Rezoning Transportation Analysis

Petition Number: 2020-011

Reviewer: Walta Blackmon, PE
walta.brumschine@ci.charlotte.nc.us
704-432-1556

Date	Description
02-18-2020	First Review
03-25-2020	Second Review

MARGARET WALLACE SUBDIVISION
 CHARLOTTE, NORTH CAROLINA
REZONING SITE PLAN

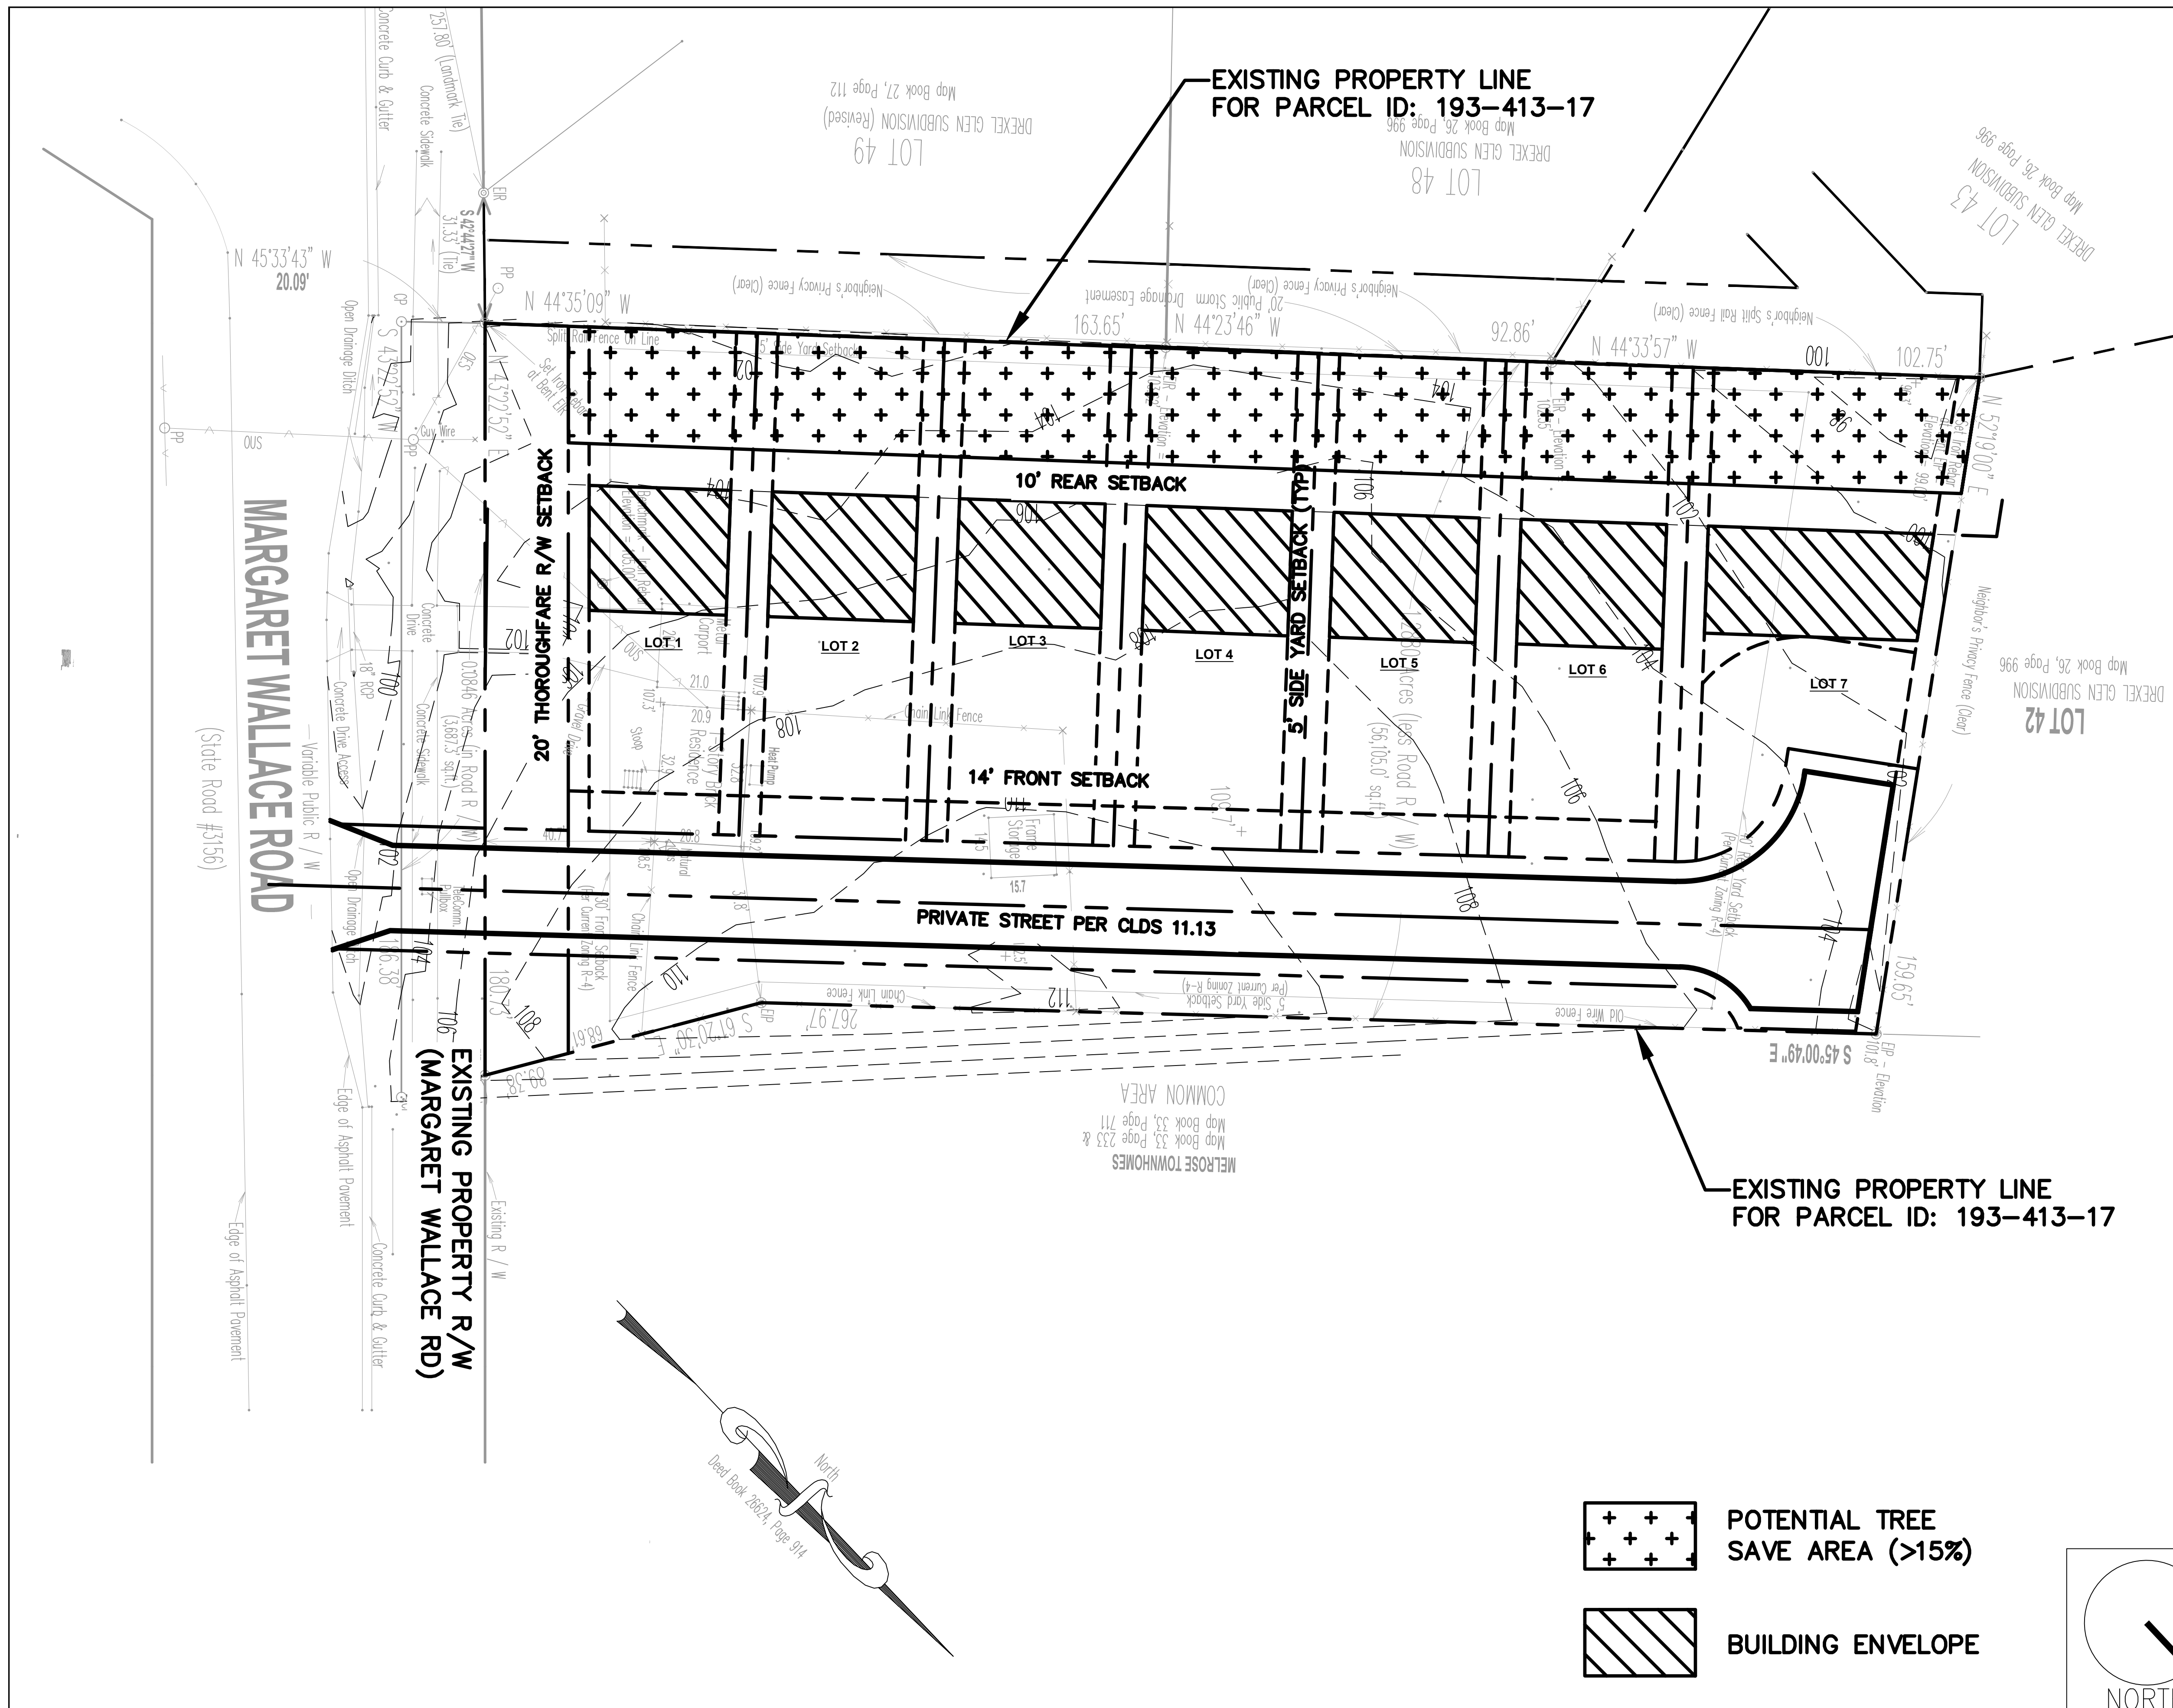
The site is located on a major thoroughfare road. The petitioner should update the site plan to meet Chapter 19th curb and gutter requirement and sidewalk along the site's frontage. In addition, the petitioner should provide a left-turn into their access due to large trips on Margaret Wallace Road.

- a. **Margaret Wallace Road:** Location of future back of curb and gutter needs to be constructed 33' from centerline.
The site plan should show the curb and gutter labeled and dimensioned from the centerline for each road.

3. The petitioner should revise the site plan and add a conditional note to commit to dedicate 50' right-of-way from the road centerline to meet CRTPO guidelines for R/W on a major thoroughfare. The site plan should label and dimension the right-of-way from the road centerline.

4. The petitioner should revise the site plan and conditional note(s) to construct the "private street" to meet USDG standards per the subdivision ordinance. CLDS U-03A

5. The petitioner should revise the site plan and conditional note(s) to construct an 8' planting strip and 6' sidewalk behind the curb and gutter to be installed.

6. CDOT is requesting the petitioner revise the site plan and conditional note(s) to connect to existing sidewalk and extend to Glen Lyon Drive to complete the pedestrian infrastructure for this block and help with meeting the City Council Adopted Charlotte Walks Policy.

7. The petitioner should revise the site plan and conditional note(s) to add a left turn lane into the proposed street connection of the site.
8. The petitioner should revise the site plan to add a note specifying dedication and fee simple conveyance of all rights of way to the City before the site's first building certificate of occupancy is issued. CDOT requests right of way set at 2' behind back of sidewalk where feasible.
9. ~~The petitioner should revise the site plan to add a note specifying all transportation improvements will be approved and constructed before the site's first building certificate of occupancy is issued. The petitioner may phase transportation improvements if said improvements and phasing are explicitly described in site plan notes.~~
